From: [REDACTED]
To: [A303 Stonehenge](#)
Subject: A303 Amesbury to Berwick Down
Date: 06 May 2022 09:42:12

In response to the request for more information re; the proposed scheme. I would like to suggest the following amendments?

Drawing Title  
FIGURE 13.3A  
PROPOSED PUBLIC RIGHTS OF WAY

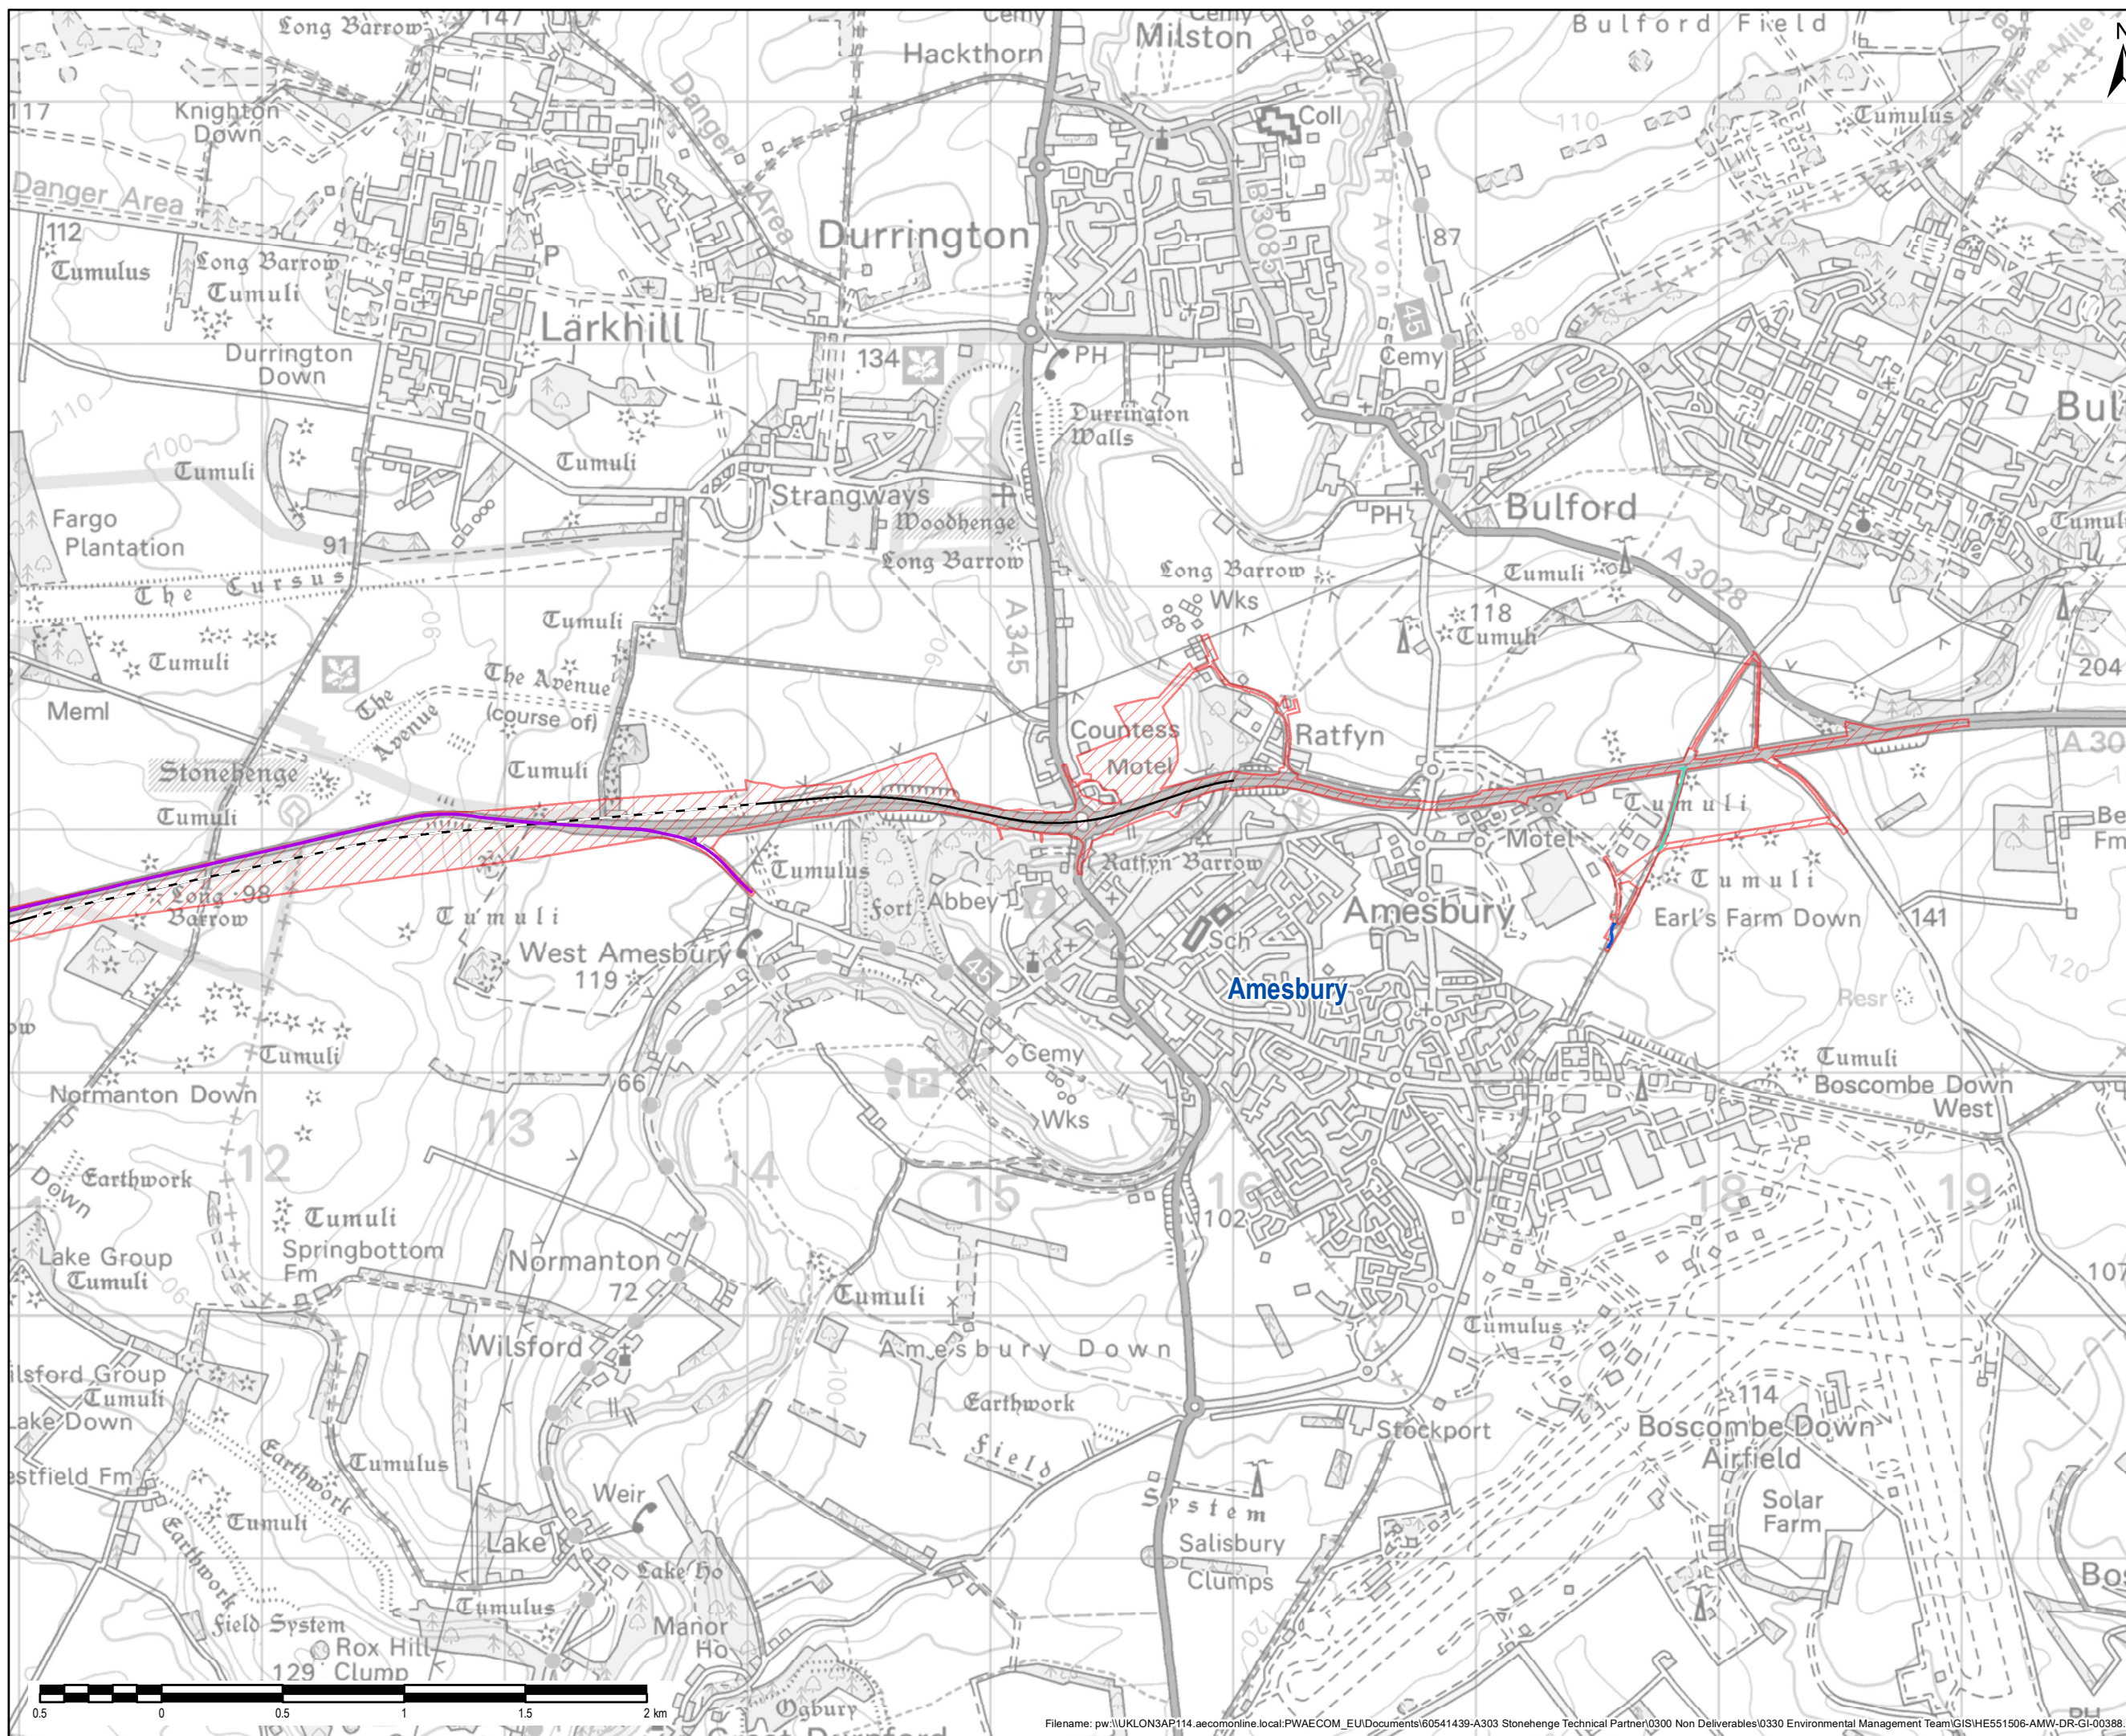
2. The planned A303 bridleway is only specified as a three metre wide shared used route. I believe this is too narrow. A four to five metre bridleway / pathway would be much more accessible for non-motorised users and facilitate more sustainable way to travel around the WHS. This would especially true, if the National Trust develop their land at Countess Barns over the forthcoming decade.
